Hampshire Water Transfer and Water Recycling Project

Draft Statement of Common Ground - Hampshire County Council

PLANNING INSPECTORATE SCHEME NUMBER: WA010002

May 2026

Sheet 4

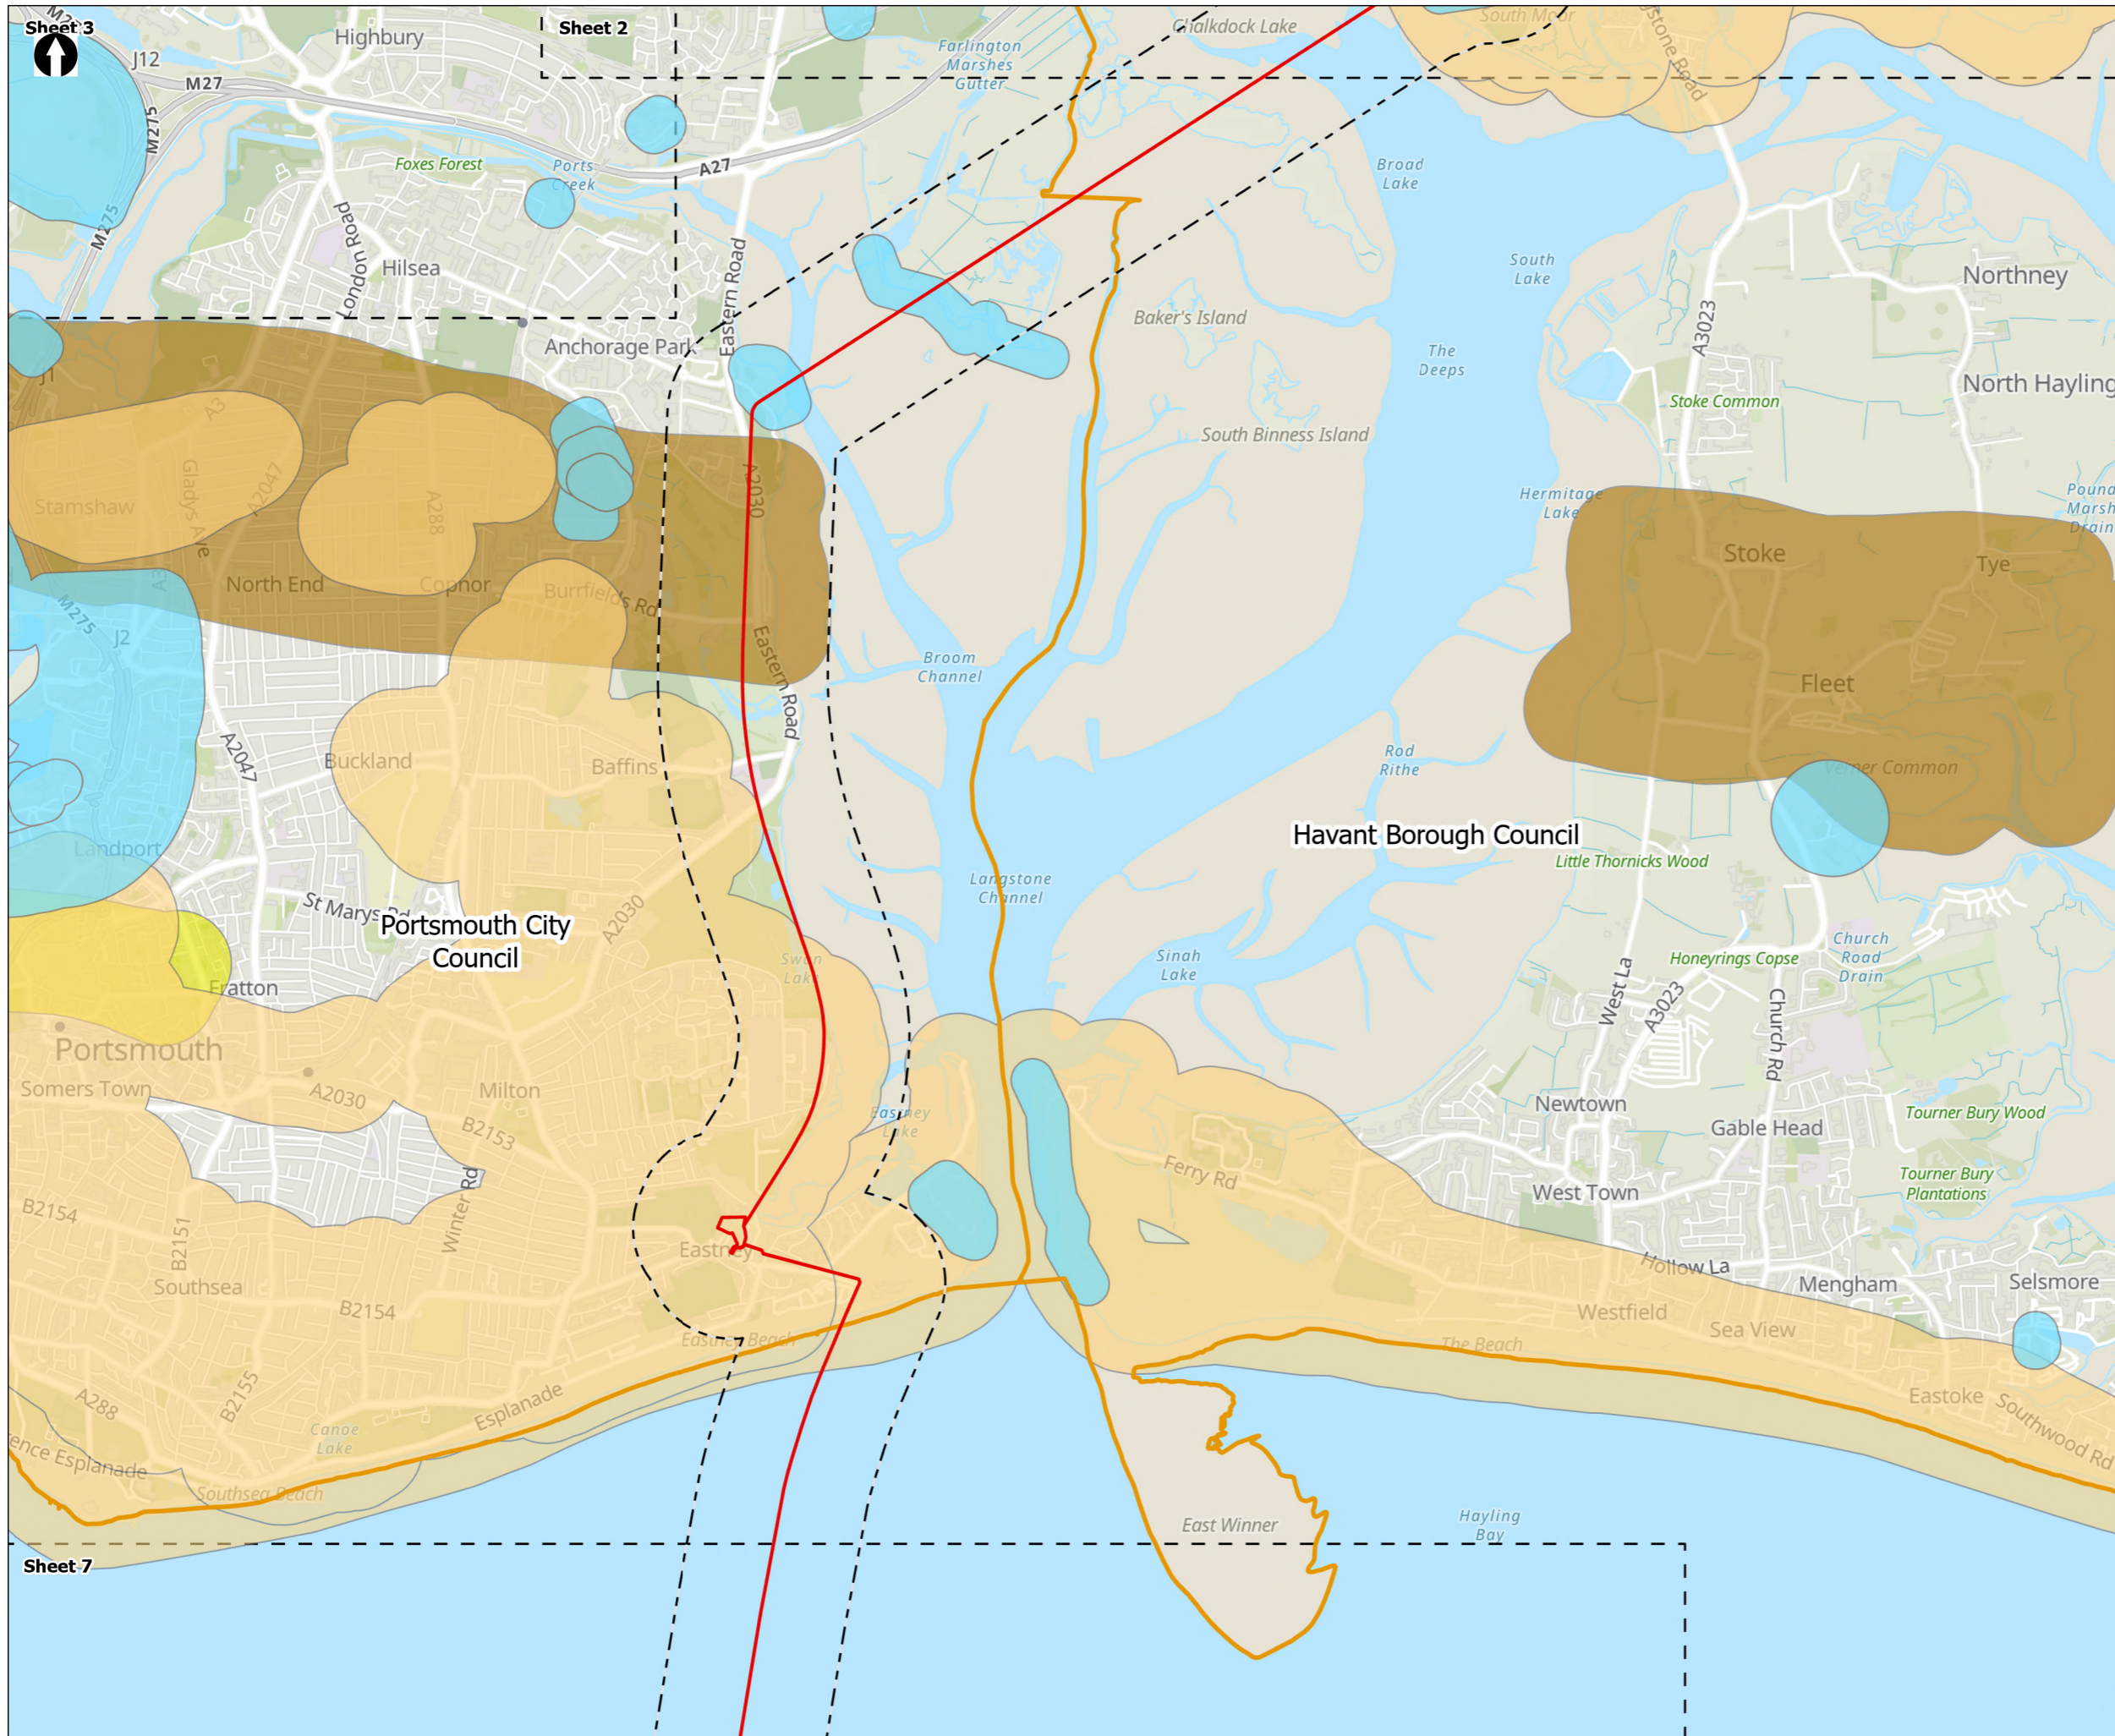
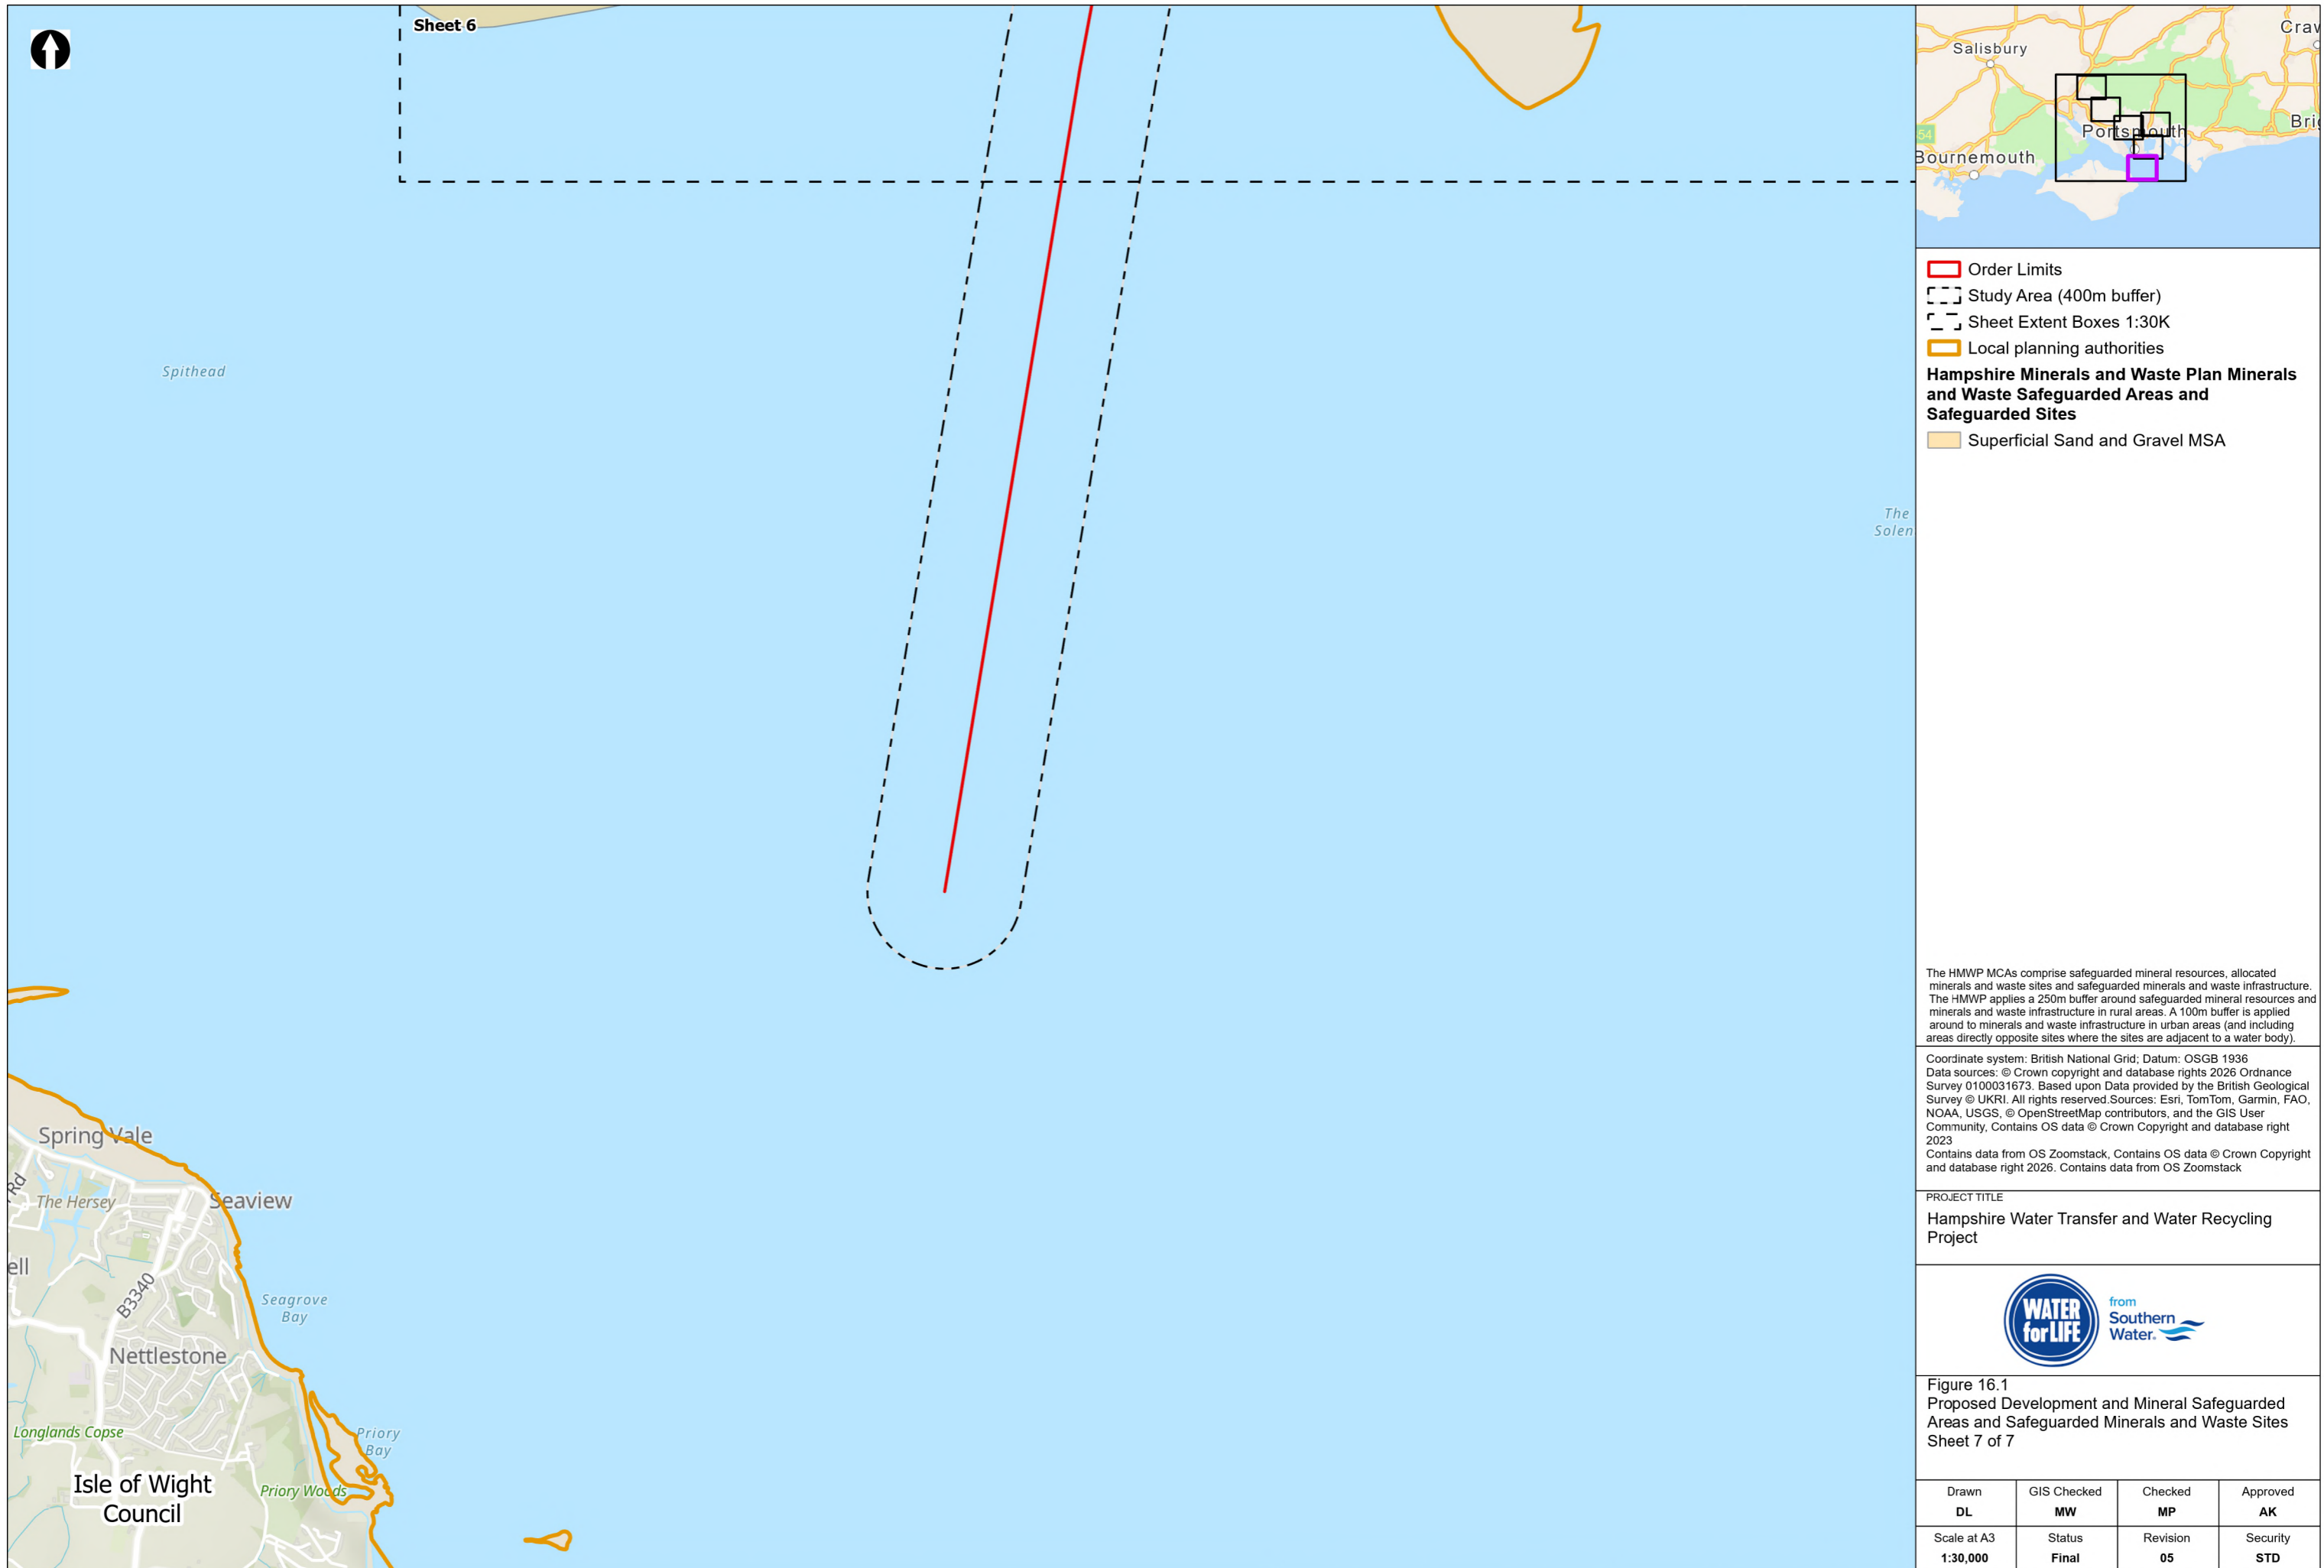
HCC-2022-0064	Resources and waste management - baseline	It is acknowledged that the 100 metres buffer is applied specifically around residential properties in accordance with the Supplementary Planning Document Minerals and Waste Safeguarding in Hampshire adopted in February 2016.	The Applicant acknowledges the HMWPA's position.		Matter agreed with other party.
HCC-2024-0189	Resources and waste management - baseline	The HMWPA supports the prior extraction of soft sand from Five Oaks Farm, in principle, to prevent sterilisation. The onus is on the landowner to pursue agreement with the developer to resolve the issue of the development of sand extraction at the Five Oaks Site, as well as the appropriate permissions from the HMWPA - but continue to bear in mind soft sand resource safeguarding and sterilisation policies of the HMWP (2013) and the emerging HMWP update.	The HMWPA supports the prior extraction of soft sand from Five Oaks Farm, in principle, to prevent sterilisation. The onus is on the landowner to pursue agreement with the developer to resolve the issue of the development of sand extraction at the Five Oaks Site, as well as the appropriate permissions from the HMWPA - but continue to bear in mind soft sand resource safeguarding and sterilisation policies of the HMWP (2013).	ES Appendix 16.1 Mineral Safeguarding Assessment, Volume II (Document reference 6.2, DCO Volume 6).	Matter agreed with other party.

HCC-2024-0159	Resources and waste management - assessment	The HMWPA supports the structured approach to assessing regional waste capacity impacts in the ES. HMWPA understands and is satisfied that the Outline CEMP (Document reference 7.1, DCO Volume 7) includes measures to produce, implement and maintain a Site Waste Management	The Applicant acknowledges the HMWPA's position.	Outline Construction Environmental Management Plan (Document reference 7.1, DCO Volume 7). ES Chapter 16 Resources and waste management, Volume I (Document	Matter agreed with other party.

HCC-2025-SC-0027	Resources and waste management - mitigation	The HMWPA notes that design refinement 24 - From Mortimers Lane (B3037) near Lower Upham to Highbridge Road (B3335), west of Brambridge, will have minimal effect on how much of the pipeline easement is within the Mineral Safeguarding Area. The Mineral Resource Assessment (MRA) will be required to understand the Applicant's assessment of how to deal with extracted minerals.	The Applicant has prepared an Appendix 16.1 Mineral Safeguarding Assessment, Volume II (Document reference 6.2, DCO Volume 6) accompanying the ES Chapter 16 Resources and waste management, Volume I (Document reference 6.1, DCO Volume 6) in response to the proportion of the land within the Order Limits coinciding with the Mineral Consultation Areas (MCA) as identified by HCC in its adopted Hampshire Minerals and Waste Plan. The Outline CEMP (Document reference 7.1, DCO Volume 7) requires the Contractor to develop a Minerals Management Strategy (MMS) as part of the	ES Appendix 16.1 Mineral Safeguarding Assessment, Volume II (Document reference 6.2, DCO Volume 6). ES Chapter 16 Resources and waste management, Volume I (Document reference 6.1, DCO Volume 6). Outline Construction Environmental Management	Matter agreed with other party.
